# A38 Derby Junctions – Issue Specific Hearing

Wed 11<sup>th</sup> December, 2019

Contribution by Derby Cycling Group

Drawing Title  
FIGURE 2.7  
LITTLE EATON JUNCTION  
GENERAL ARRANGEMENT

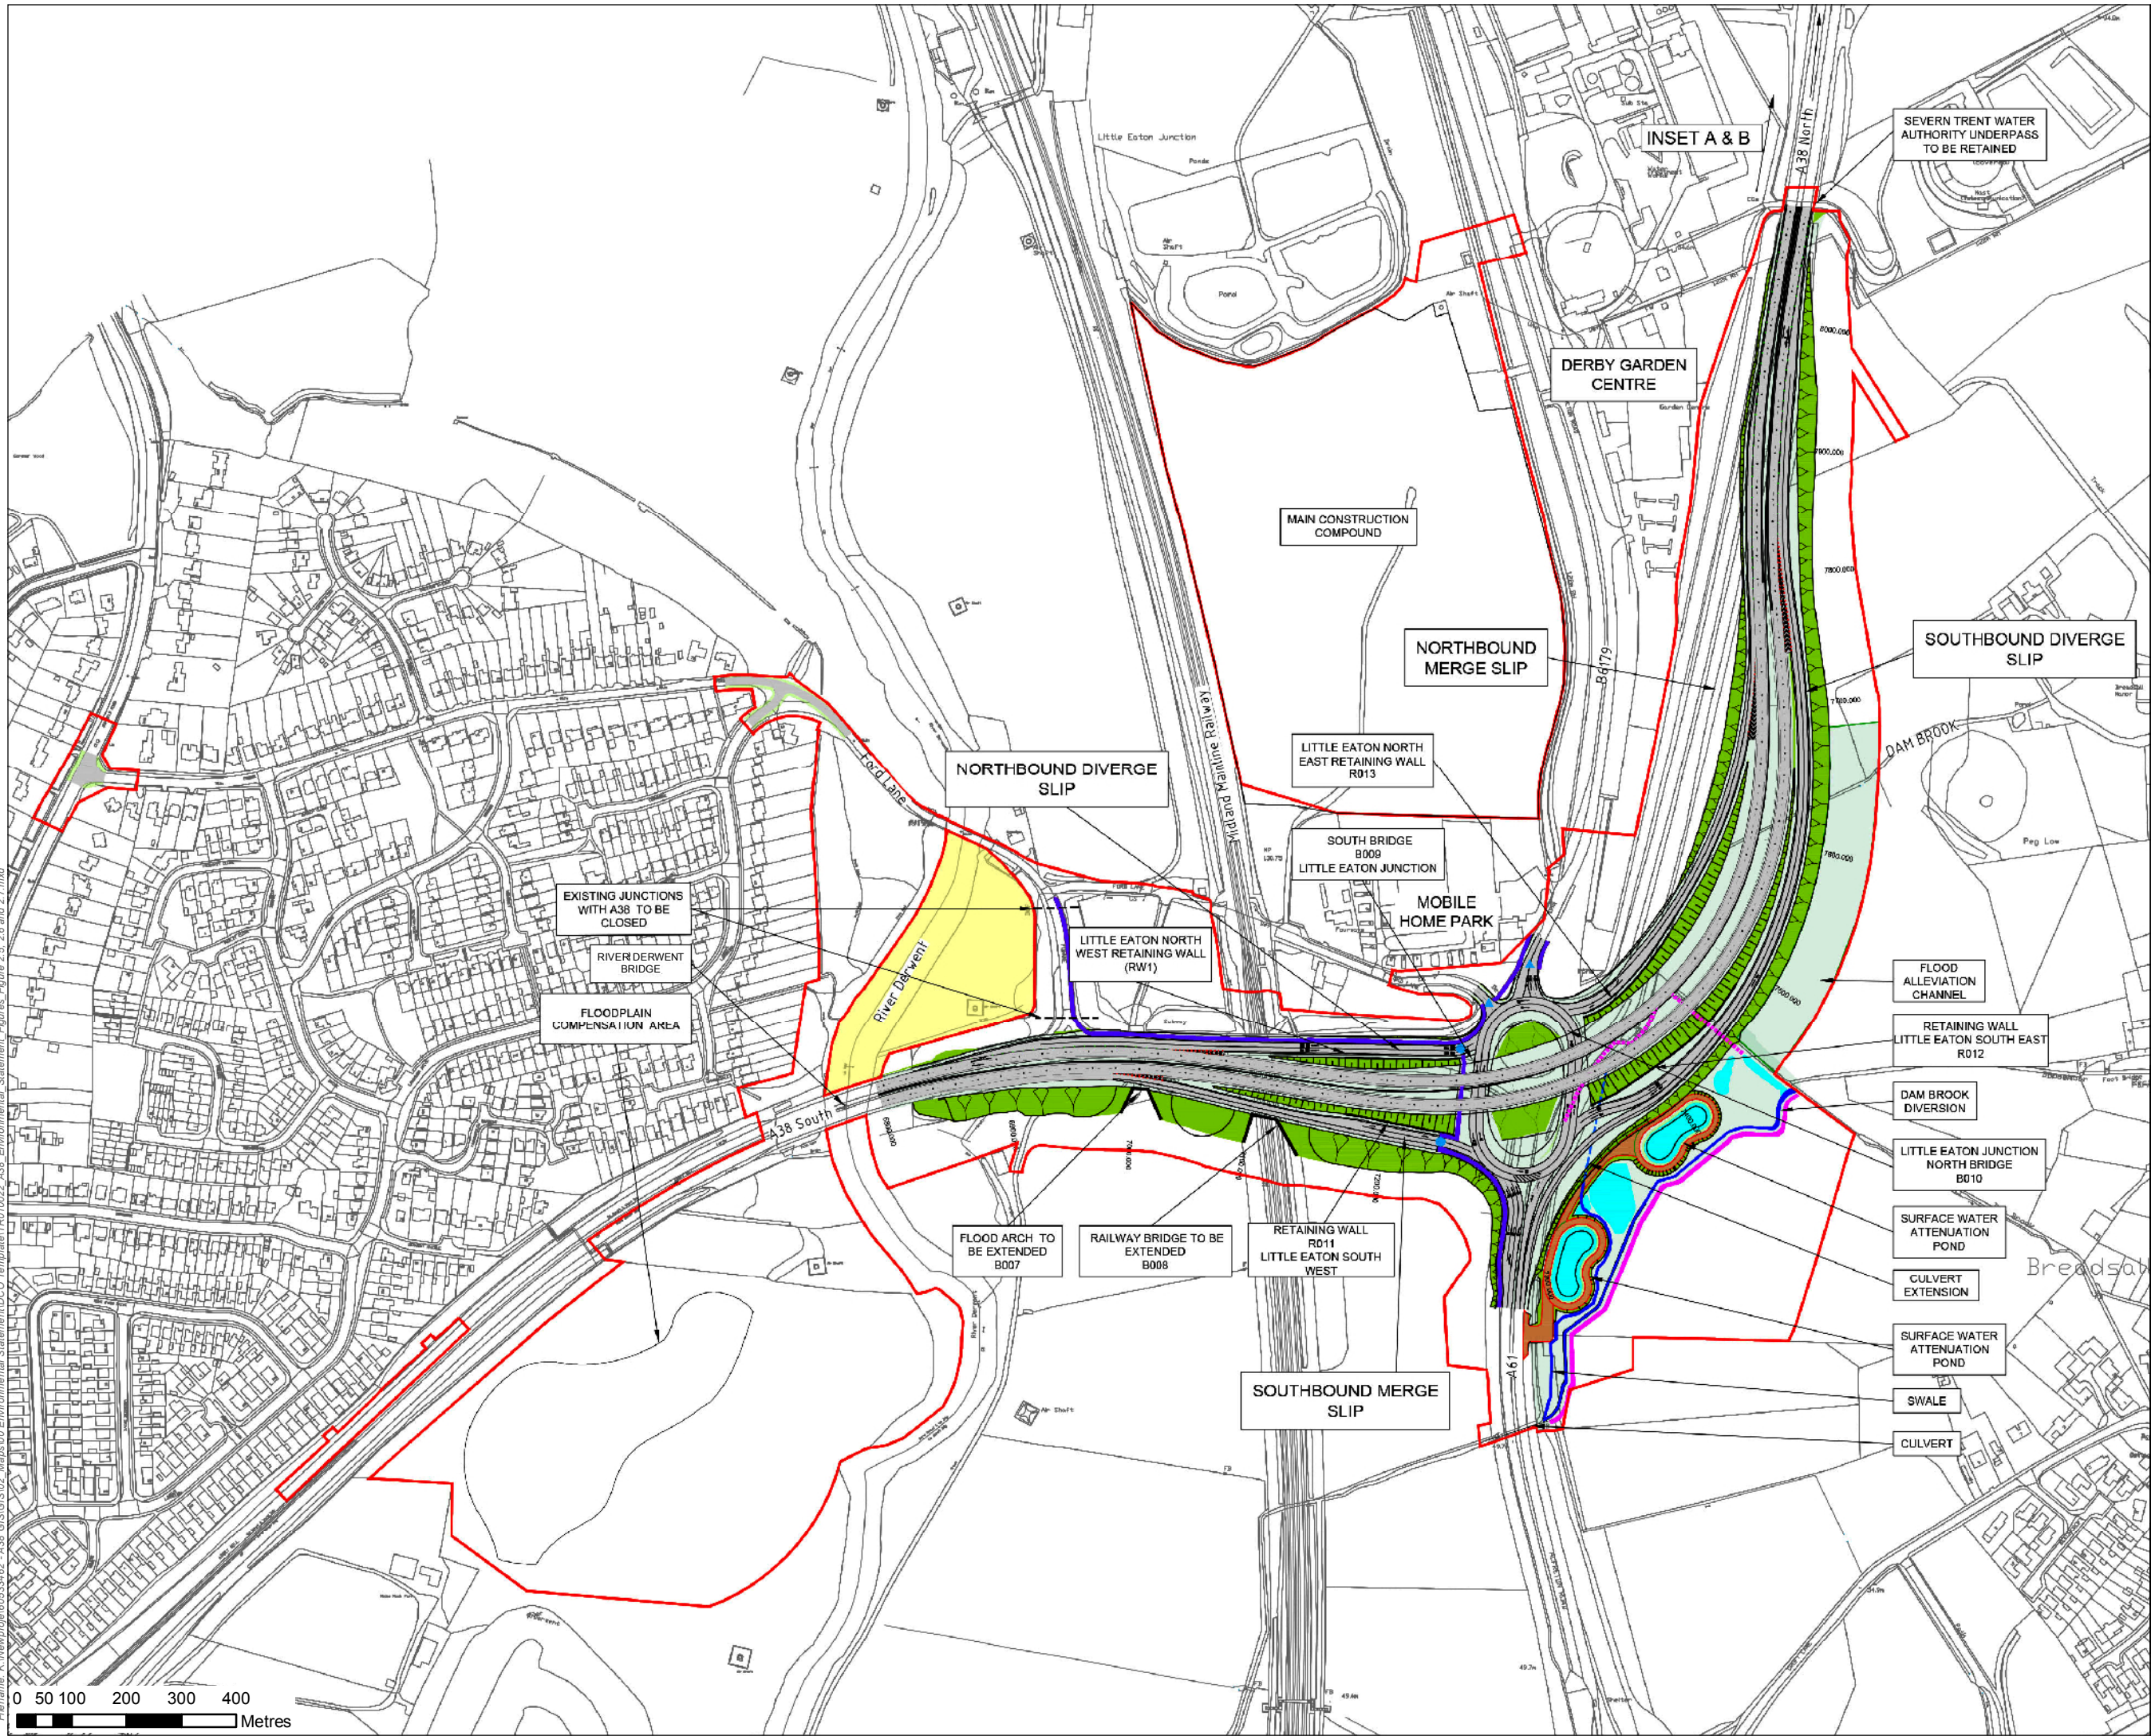
- 14c Derwent Valley Cycleway:
  - We understand that the part of the Derwent Valley Cycleway will be built from Haslams Lane to Ford Lane (and possibly beyond) using designated funds. If that is the case, we are delighted that the project will effectively be delivering this new route.
  - We do have an issue with how the Derwent Valley Cycleway will then connect with the Little Eaton roundabout; currently the path is constrained to little more than 1m width between the rail

bridge abutment and vehicle restraint barriers. This is highly substandard (two people can barely walk past each other here, never mind cycle past each other) however we have been told that this will remain unchanged.

- We have submitted ideas regarding how this can be made into a good quality NMU route (ie the distance between the solid barriers to be at very least 4m wide) and would like that to be taken forward by the project team.

- **Little Eaton:** There needs to be a description of the design for the retained route between Little Eaton island and Ford Lane alongside A38. This is currently sub-standard design and needs upgrading (ref section 14c above).

- Discontinuous cycle routes and the lack of a controlled crossing on the A52 across the entrance to the Macdonalds/Esso garage site (12)
  - A significantly sub-standard route (ridiculously narrow) alongside the A38 between Little Eaton island and Ford Lane where it crosses the rail bridge. (14c)

- Lack of marked crossings over the Ford Lane exit from the Little Eaton junction and at the Starbucks entrance.
  - A general reluctance to introduce segregation: pedestrian/cycle segregation should be the standard because these routes have the potential to become very well used, and indeed the A61 cycle path already is well used.
